Response to WSCC comments December 2017.

**WEST SUSSEX COUNTY COUNCIL
PLANNING SERVICES CONSULTATION**

SUBJECT: LU/278/17/RES - Approval of Reserved Matters following Outline Permission LU/47/11 for Construction of the southern section of the Lyminster Bypass, including northern and southern roundabouts, surface water drainage and landscaping. Departure from the Development Plan & affects a Public Right of Way.

LOCATION: North Littlehampton Strategic Development Site, Land West of Toddington Park, Toddington Lane, Littlehampton, BN17 7PP.

Landscape Proposals: SLB3
Northern roundabout

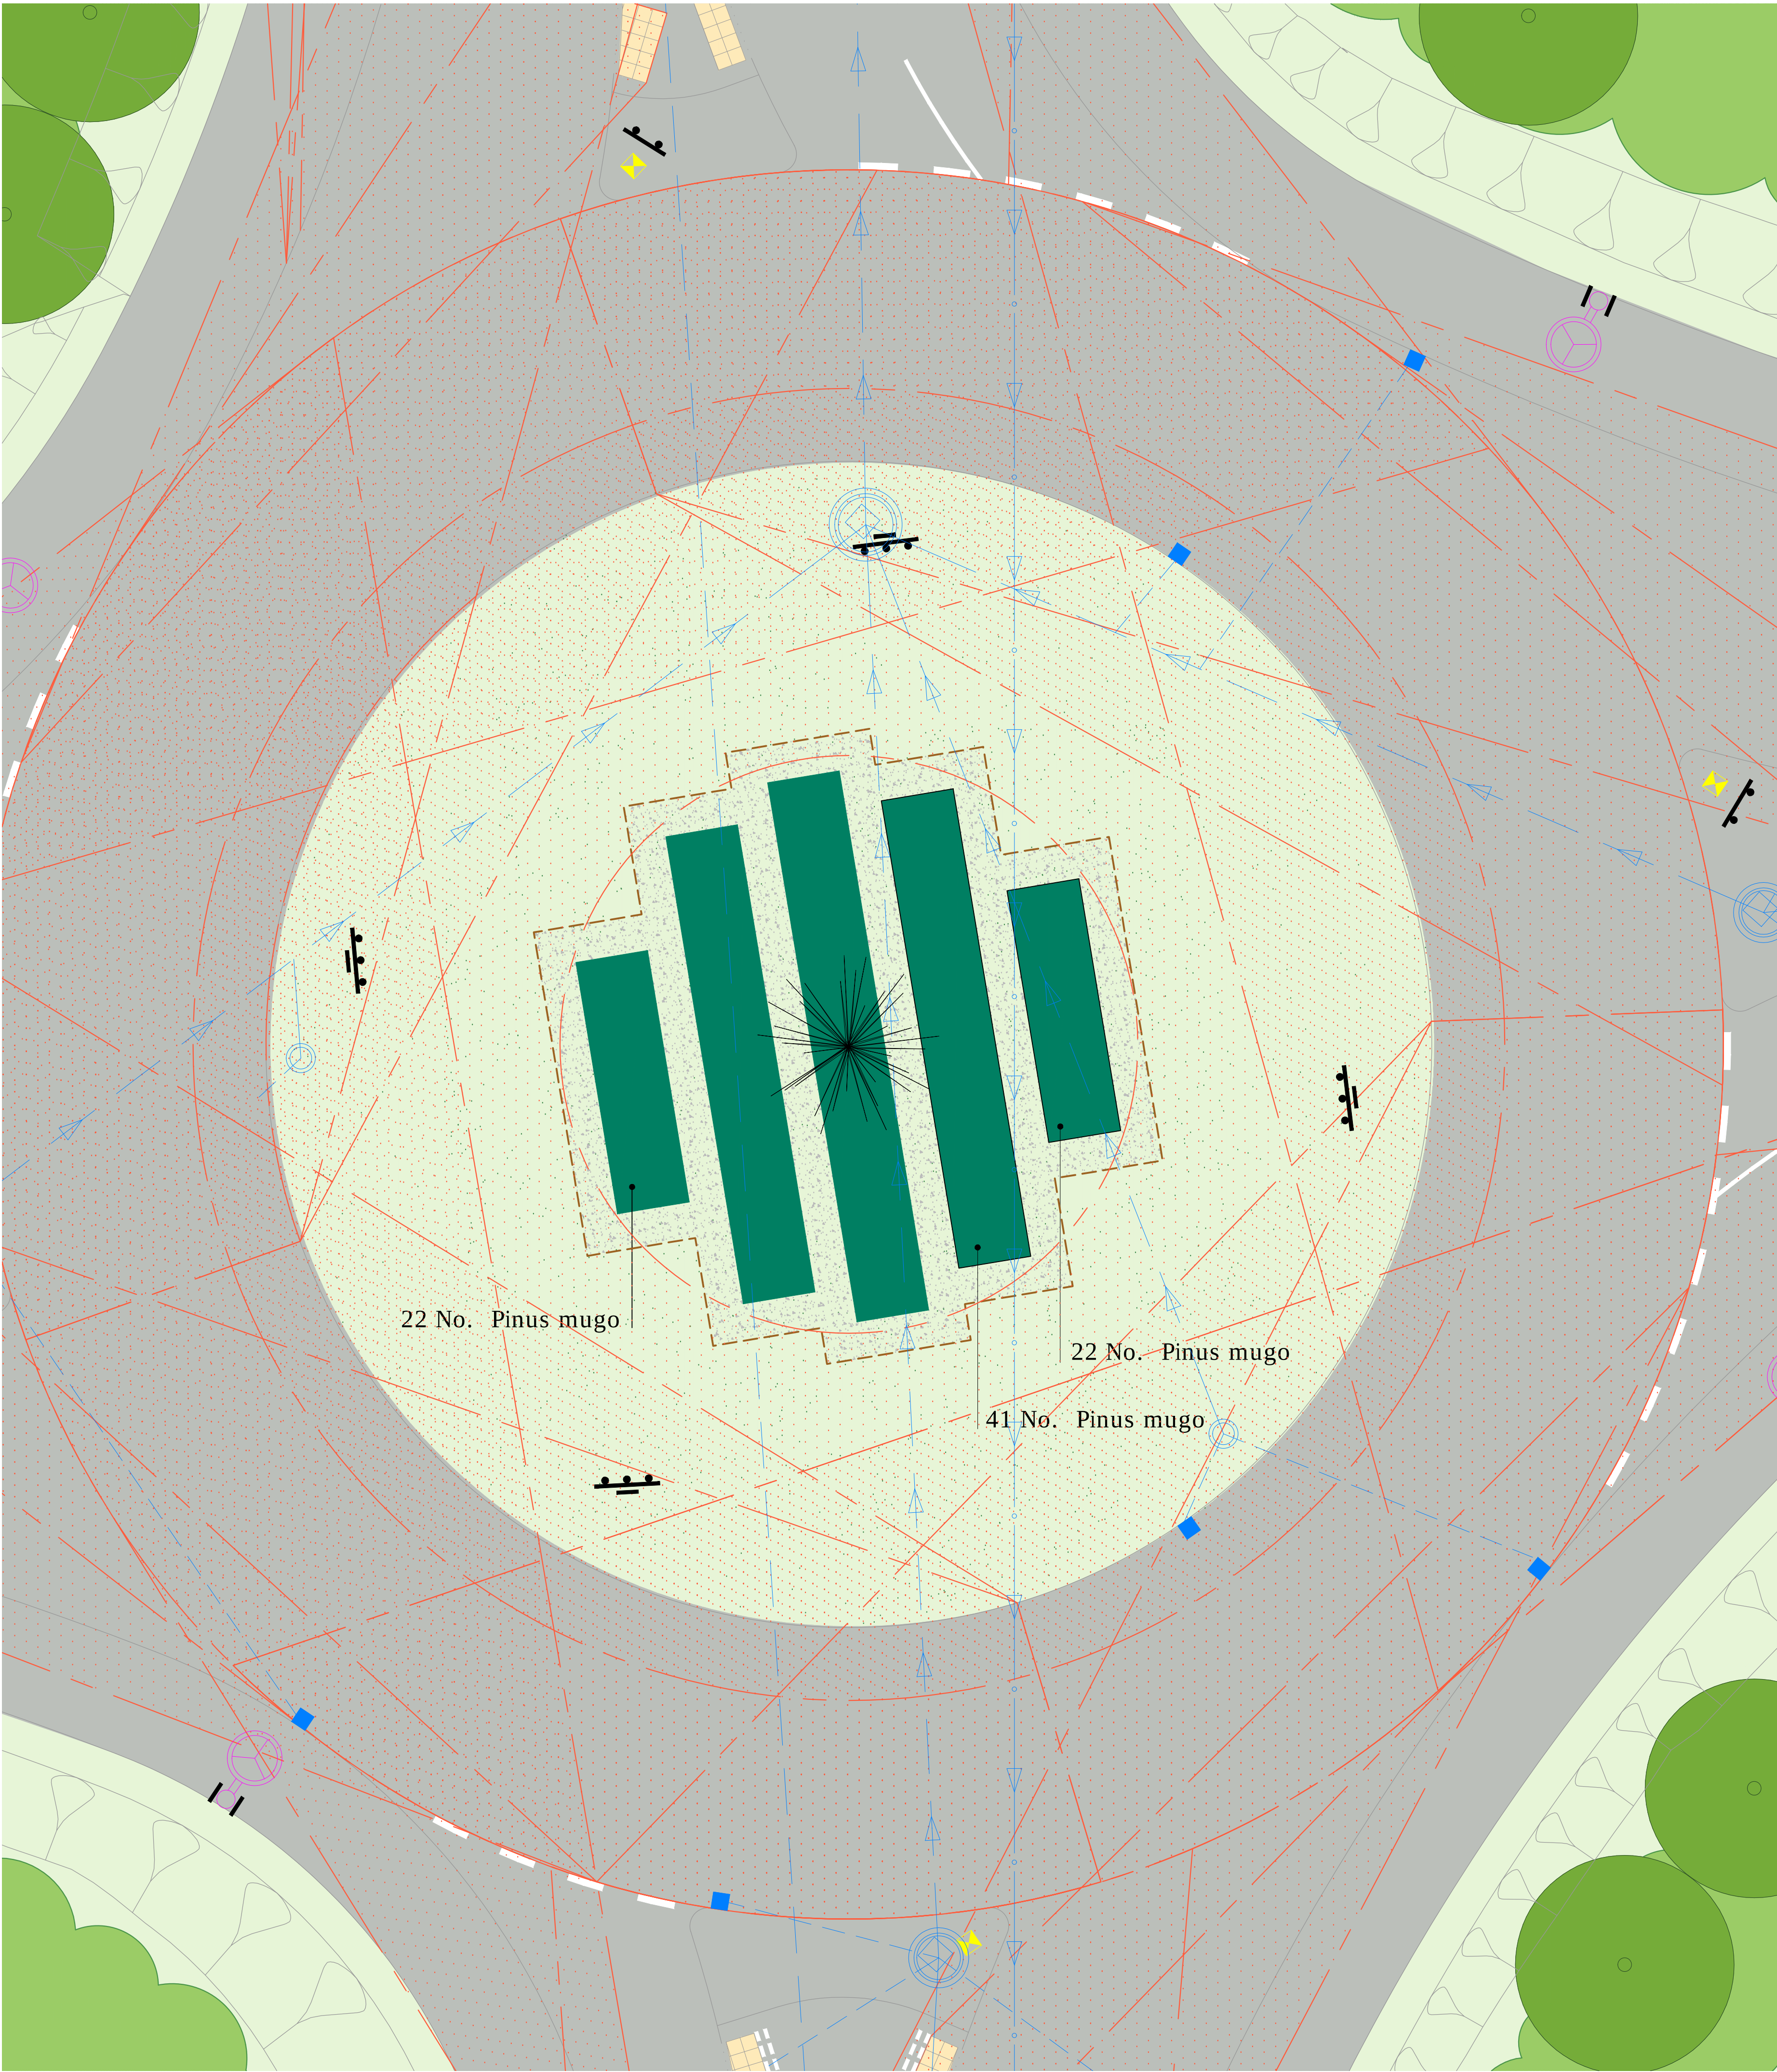
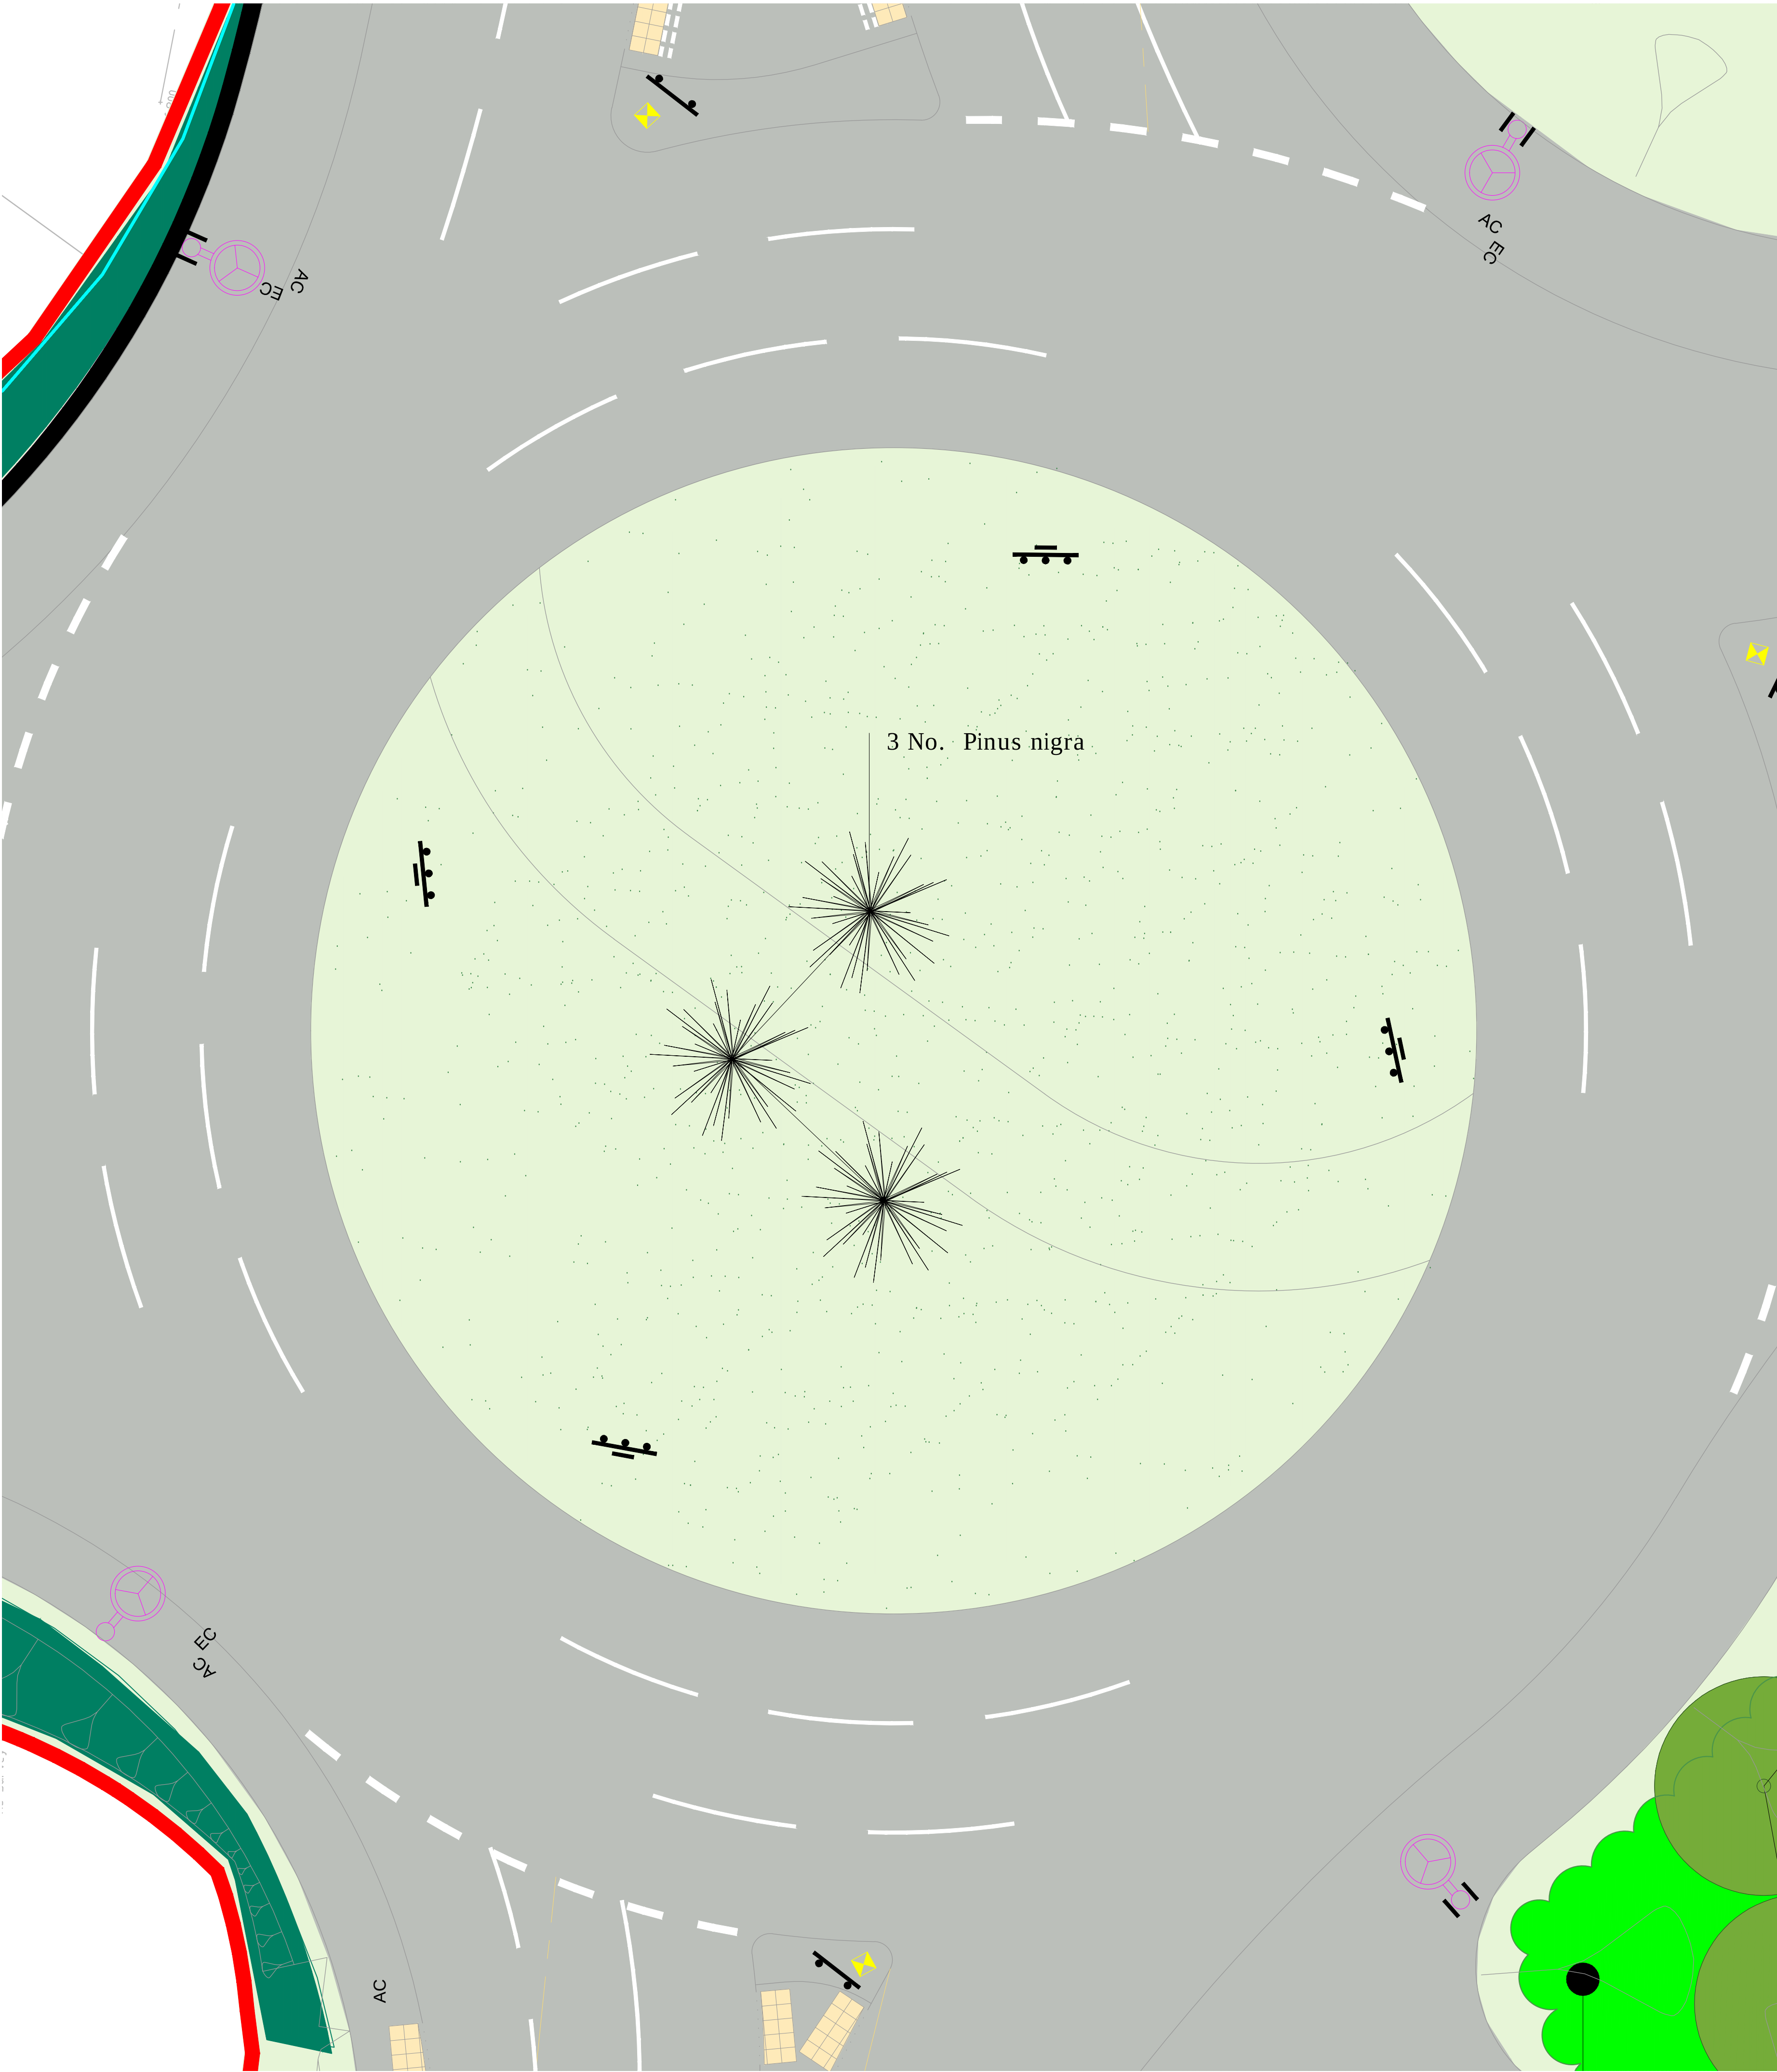
There should be no planting on the cellular storage areas, other than grass. WYG Landscape Response: Changes made

The wooden sleepers on the roundabout islands should be removed as they present a hazard should traffic collide with them. Such features would also hinder maintenance to the underlying cellular drainage system. WYG Landscape Response: Noted. The timber features have been removed and replaced with soft landscaping where it can be accommodated.

Timber features and ground-cover ivy have been removed from both roundabouts. **Northern roundabout:** underground storage tank has been removed. Pine trees and ground-cover pine are proposed within the centre of the roundabout (outside the visibility splays). **Southern roundabout:** Storage tank remains. Pine trees are proposed within the centre of the roundabout.
